Memorandum ABP-317810 - Request for Further Information under Section 131

To: Paul Caprani, ADP
From: Laura Finn, PI
Re: 317810 - Request for Further Information
Date: 12th January 2024

Re: Open Cycle Gas turbine power plant (350MW) and associated infrastructure
Located on land to the north of Tynagh Power Station, Derryfrench, Tynagh, Loughrea, Co. Galway.

Our Ref PAR 4169

Figure 2: Wind Rose for Athenry meteorological station (2018 – 2022)

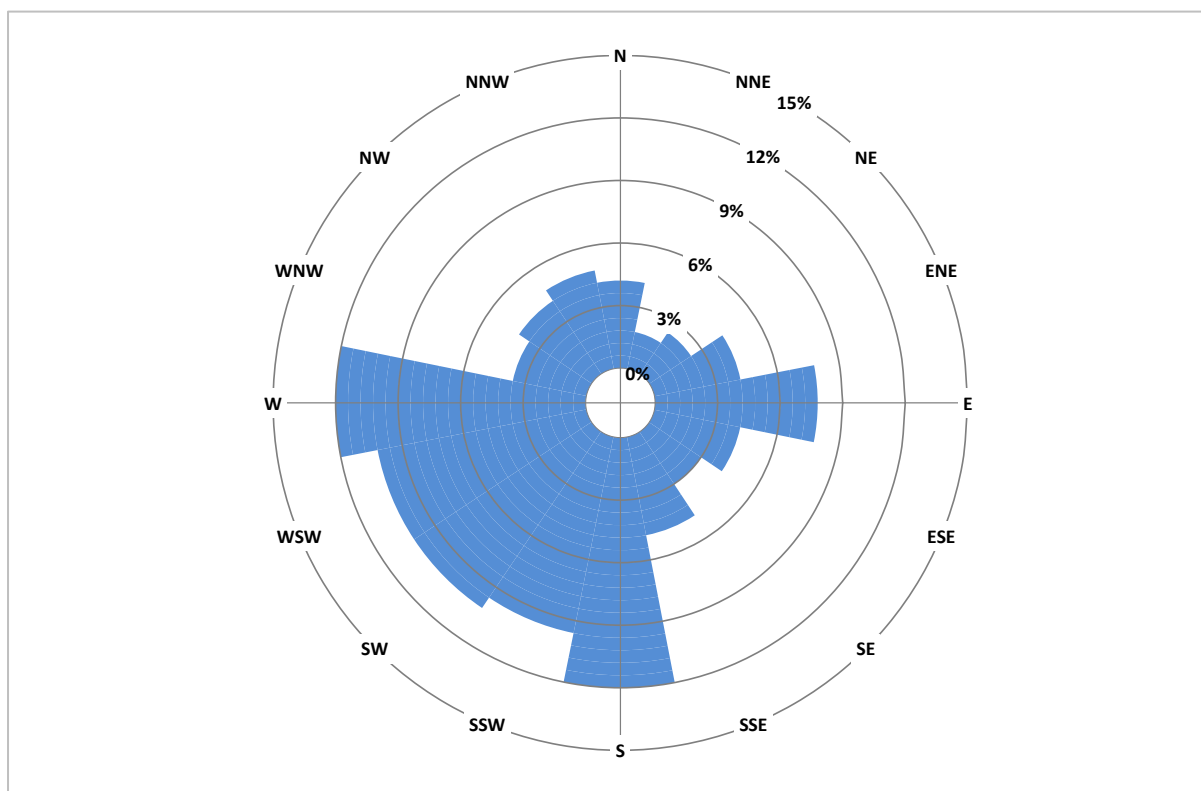
12. Section 5.2.2.2 – provide detail on meteorological data probabilities (i.e. 80/20 for D5/F2) or wind rose, which are relevant for flash fires for gas releases.

Figure 3: Key Tank and Bund dimensions for calculation of bund overtopping

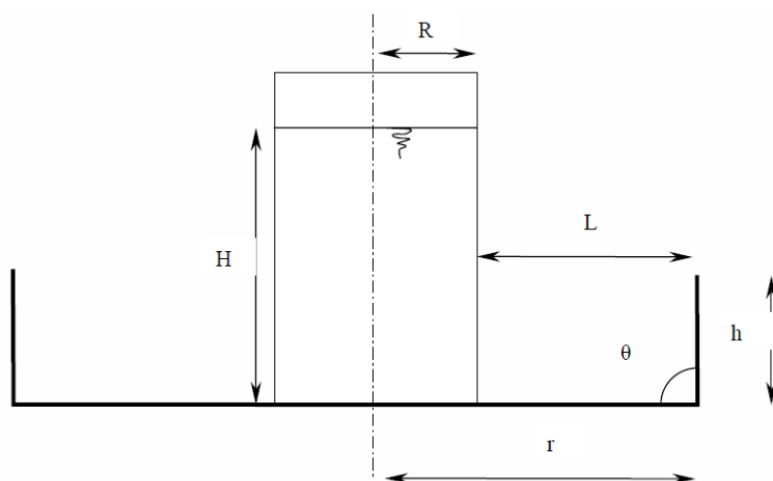
17. Section 5.3.2 – what frequency has been used for an overtop pool fire? TLUP Section 3.6.3 indicates 5×10^{-3} /yr per tank, provide further detail.

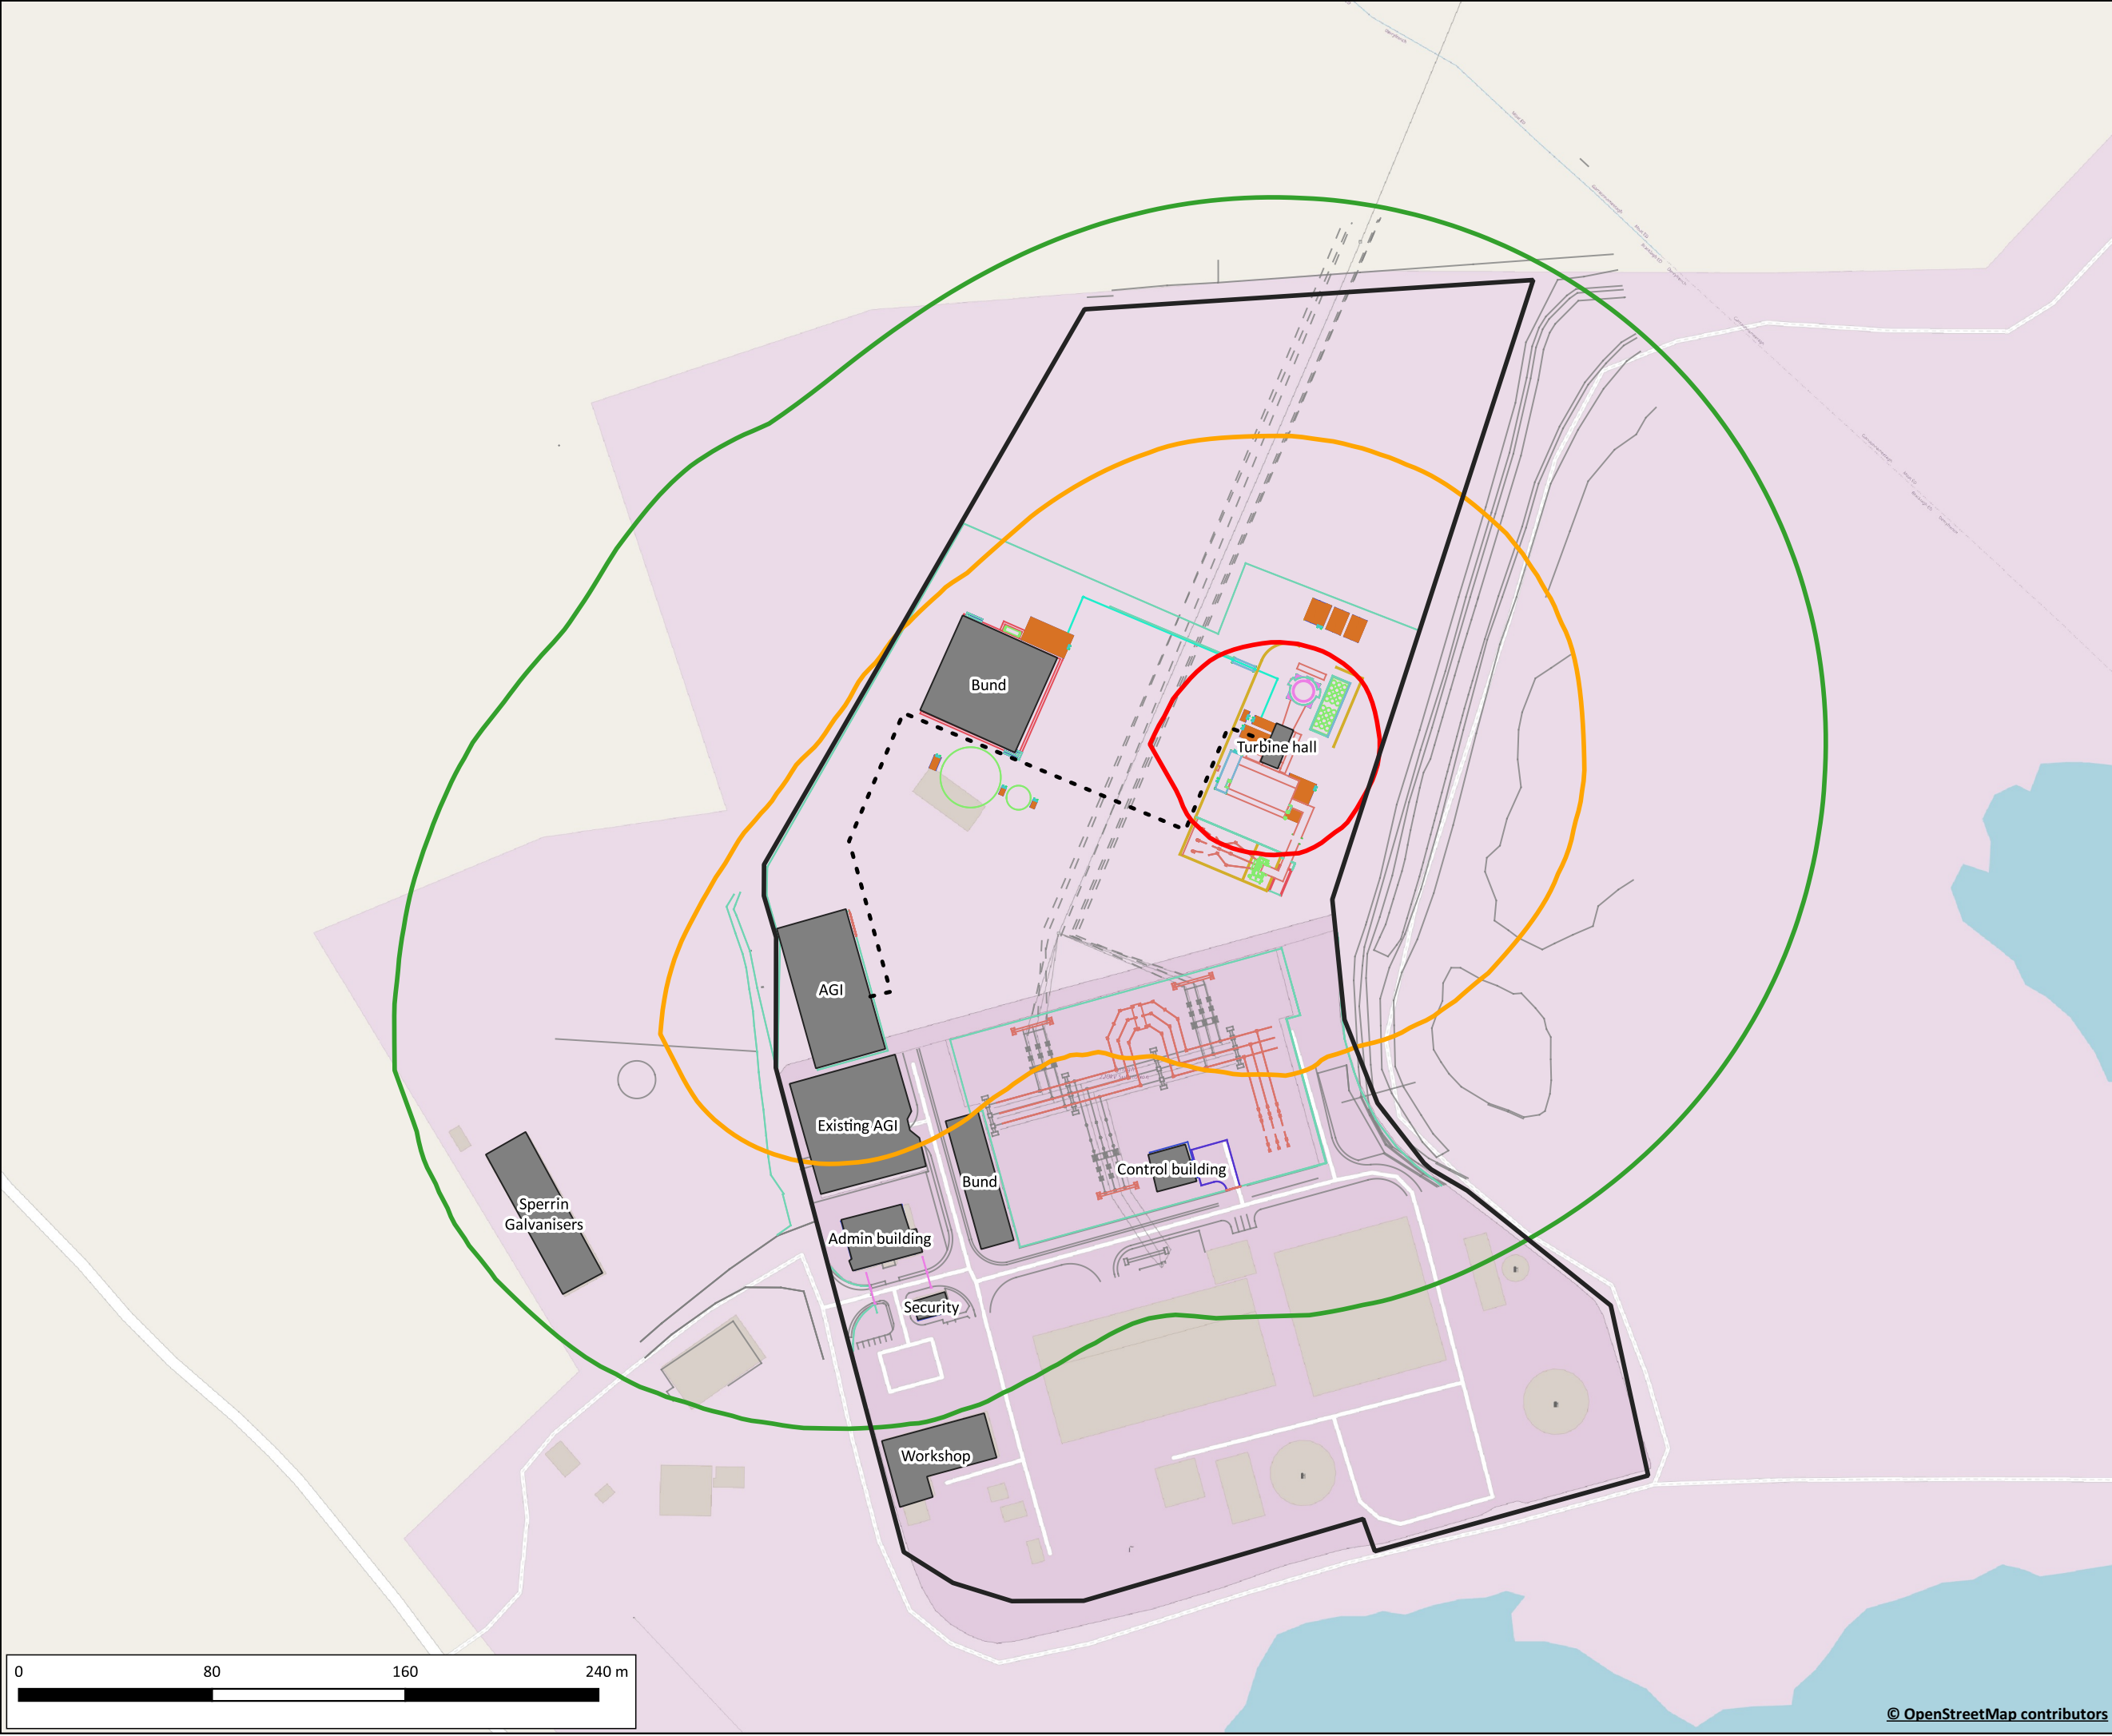
1. The report should include a drawing showing the site boundaries and the location/routes of all major hazards for all three COMAH installations – the current Tynagh Energy site, along with the Tynagh South and North sites. The drawing should show over ground and underground gas pipelines, AGIs, fuel storage bunds, CCGT and OCGT gas turbine enclosure locations, power station turbine hall, hydrogen operations etc. The report does not make clear the location of the Tynagh North OCGT turbine enclosures (only the AGI, fuel bund and underground gas pipelines are shown).
